Worlington Parish Council

Response to the Applicant in regards to Green Lane

Unique no: 20030919

Green Lane/ Badlingham Lane U6006

Drawing Title
**FIGURE 3-19A
CONSTRUCTION COMPOUNDS &
ACCESS SUNNICA EAST
SITES A AND B**

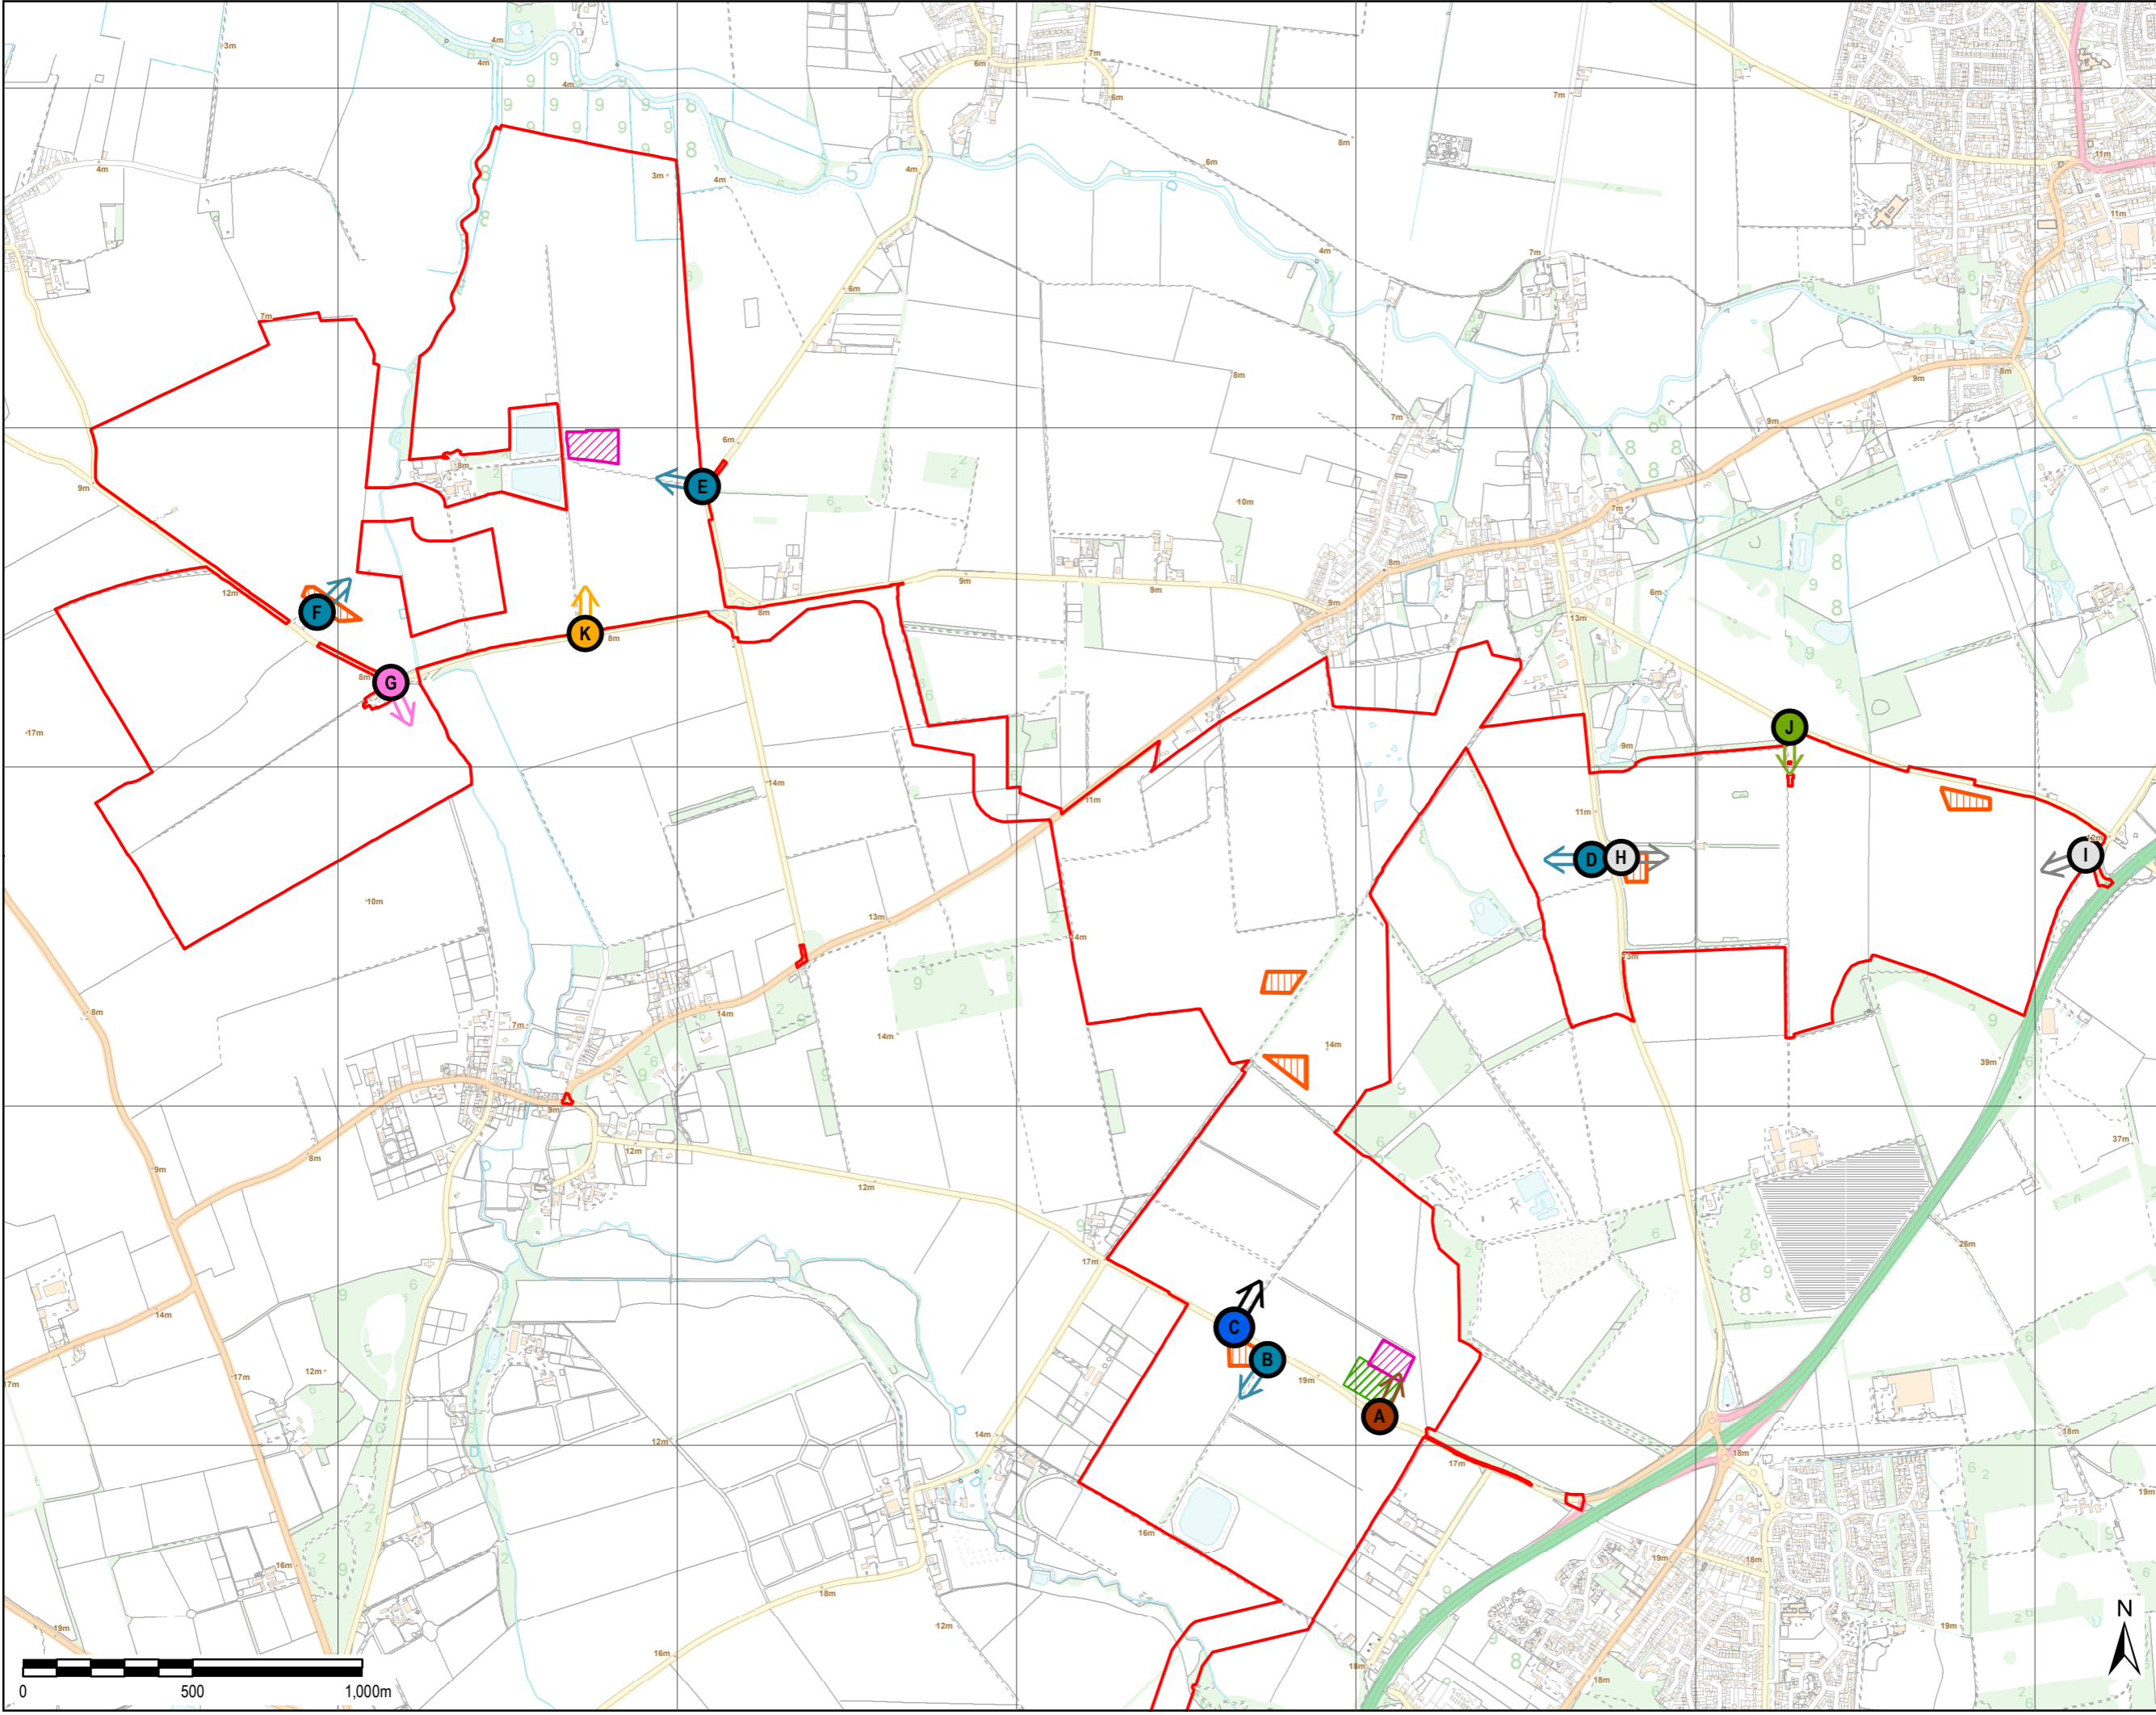
By creating site accesses the applicant has added a risk factor to those using the track.

What volume of vehicles will be crossing?

What type of vehicles?

What times of day will the crossing be used.

What happens if during construction or completion it is deemed too dangerous to allow public past?

The applicant stated fencing will be placed along each side of the track. Though this may be placed behind the existing tree line it will be visible. Part of the beauty of this area is seeing the fields beyond where the trees thin. Deer often frequent this area but will no longer be able to pass through. A fence with gaps even for smaller animals like hedgehogs is still a fence, still a barrier to keep things apart.

- The applicant proposed tarmacking vehicle crossing points- on an earth lane
- Proposing an alternative route while the lane is closed along a 60mph road without foot paths.

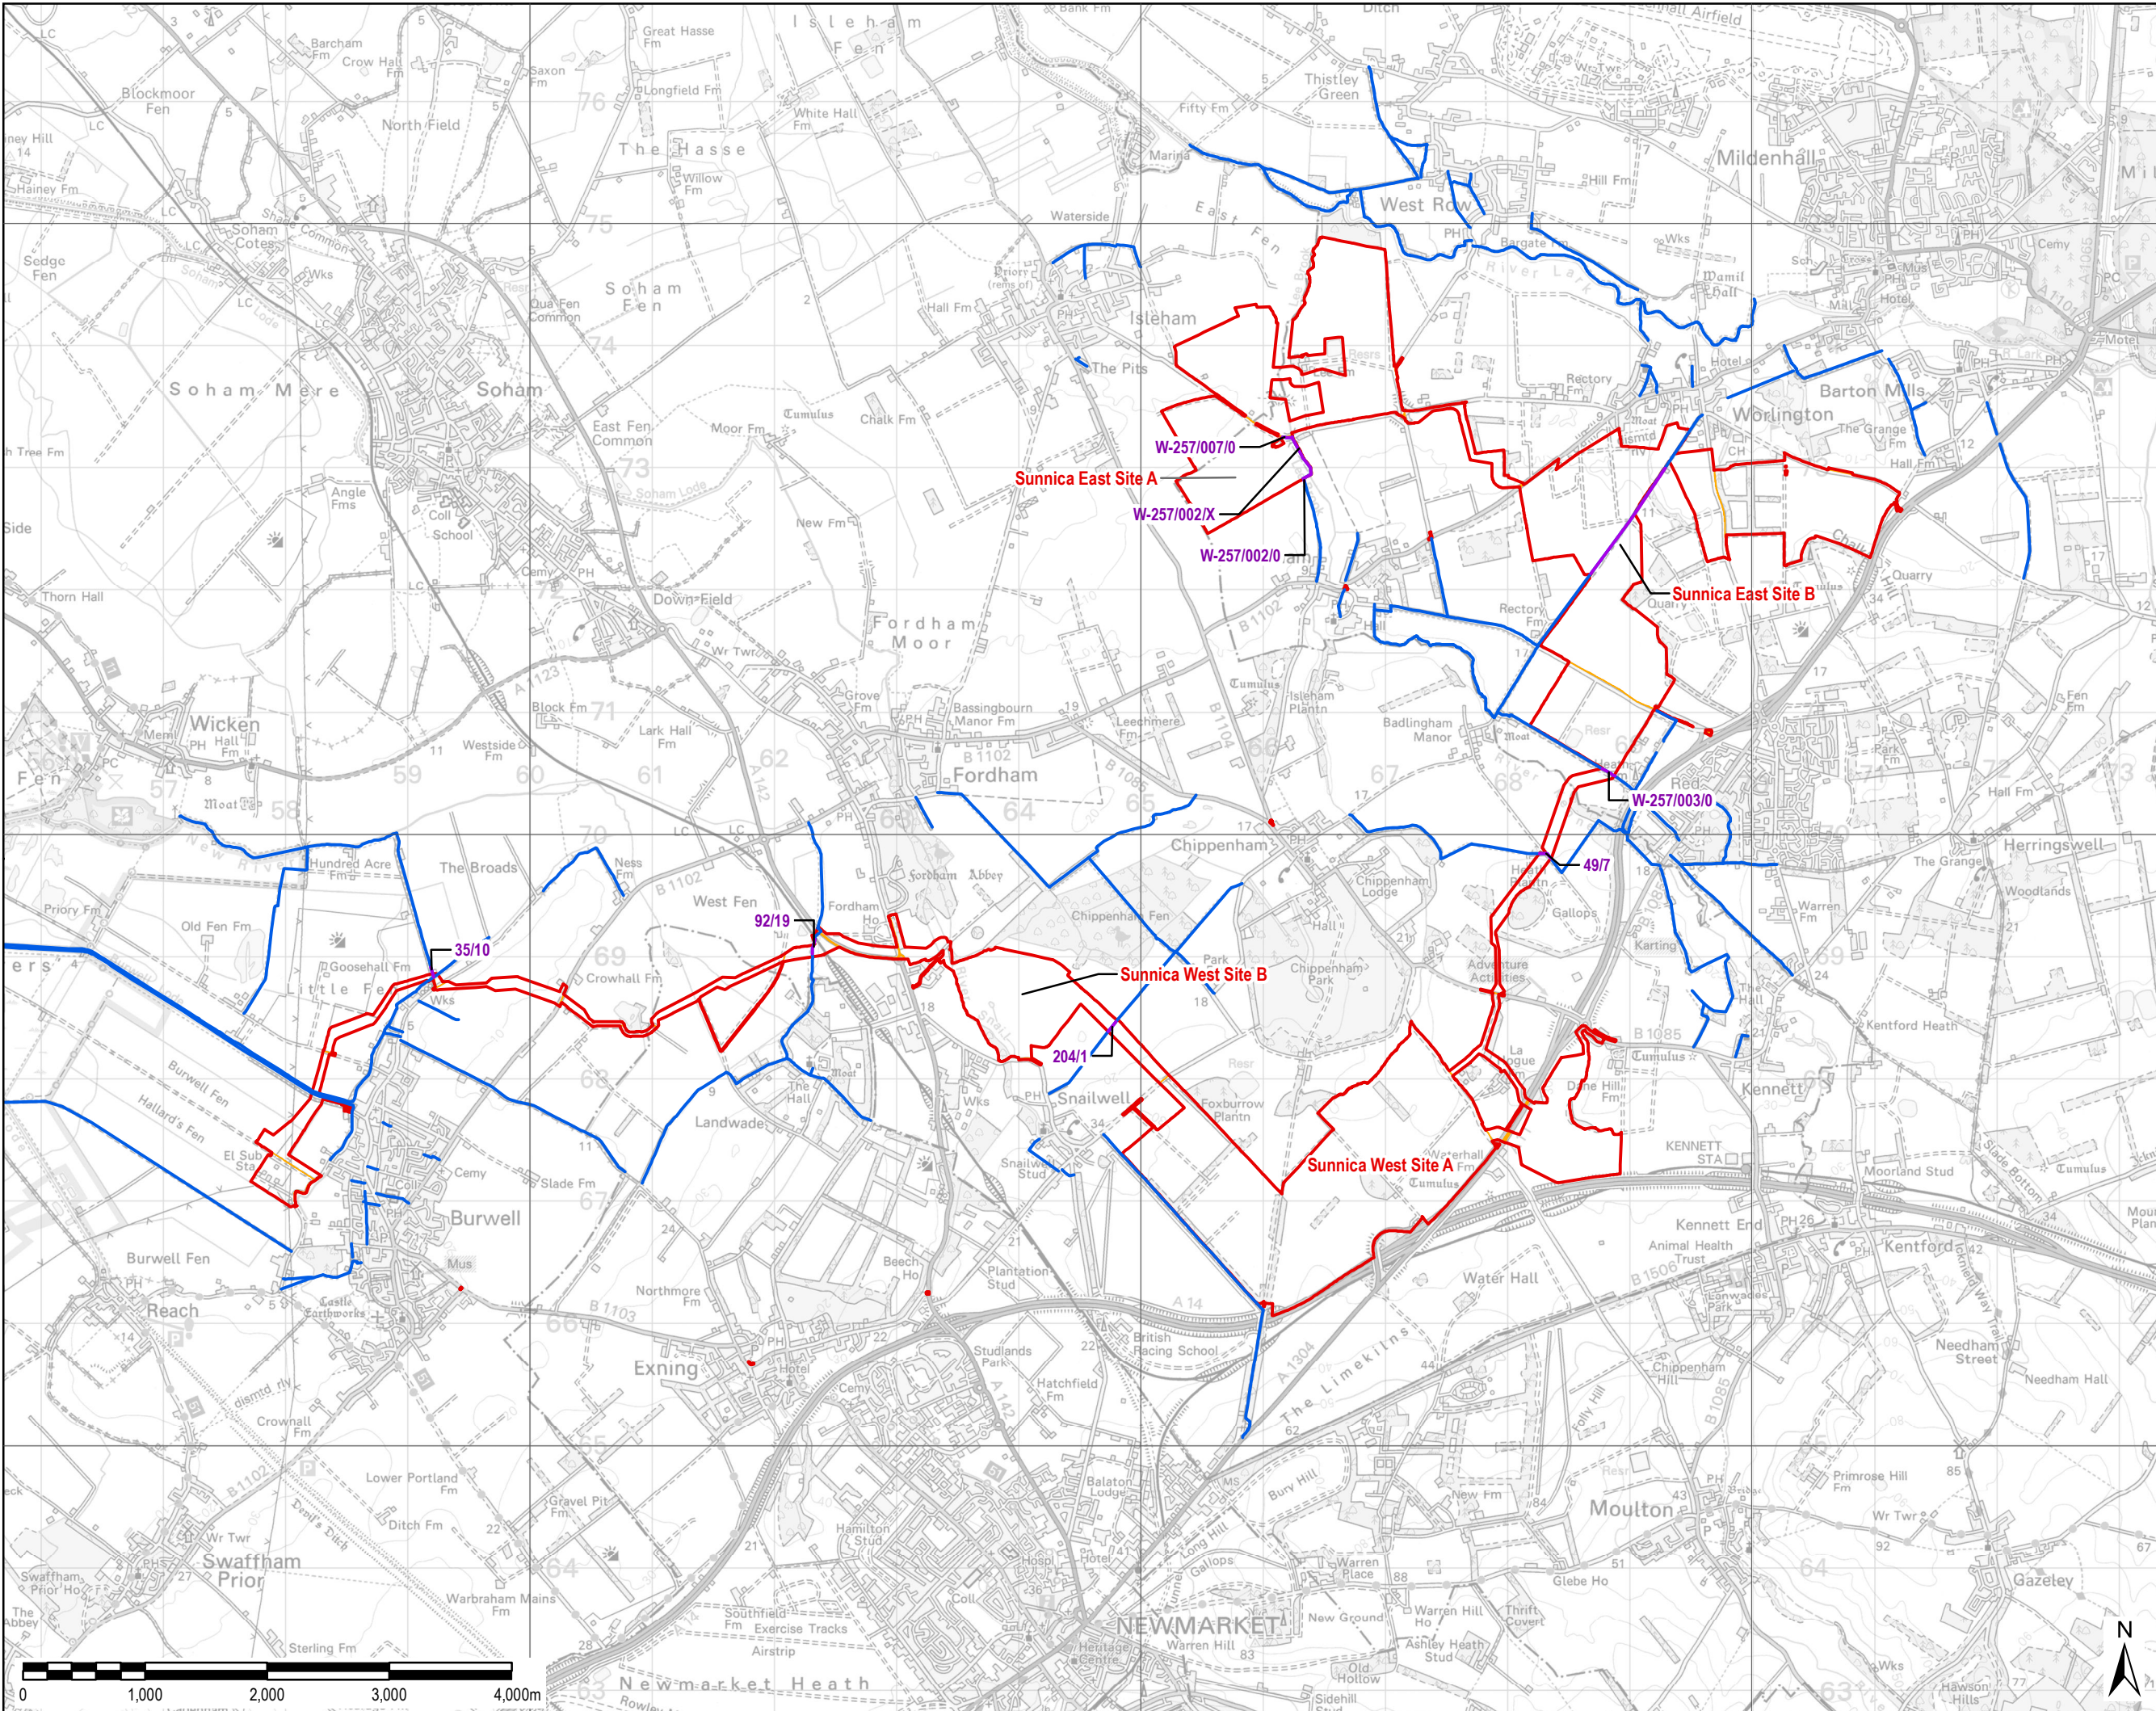
Taking away one of two easily accessible walking routes and cutting our village off from our neighbours will have a devastating effect on the communities. The applicant states it will only be closed for a few weeks. The applicant fails to acknowledge they will be changing the vista to an industrialised one, crossing points with daily vehicle movement, added noise both during and after construction and the removal of trees and scrub and the addition of fencing. All of this will impact the area and take away the reason why it is now used.
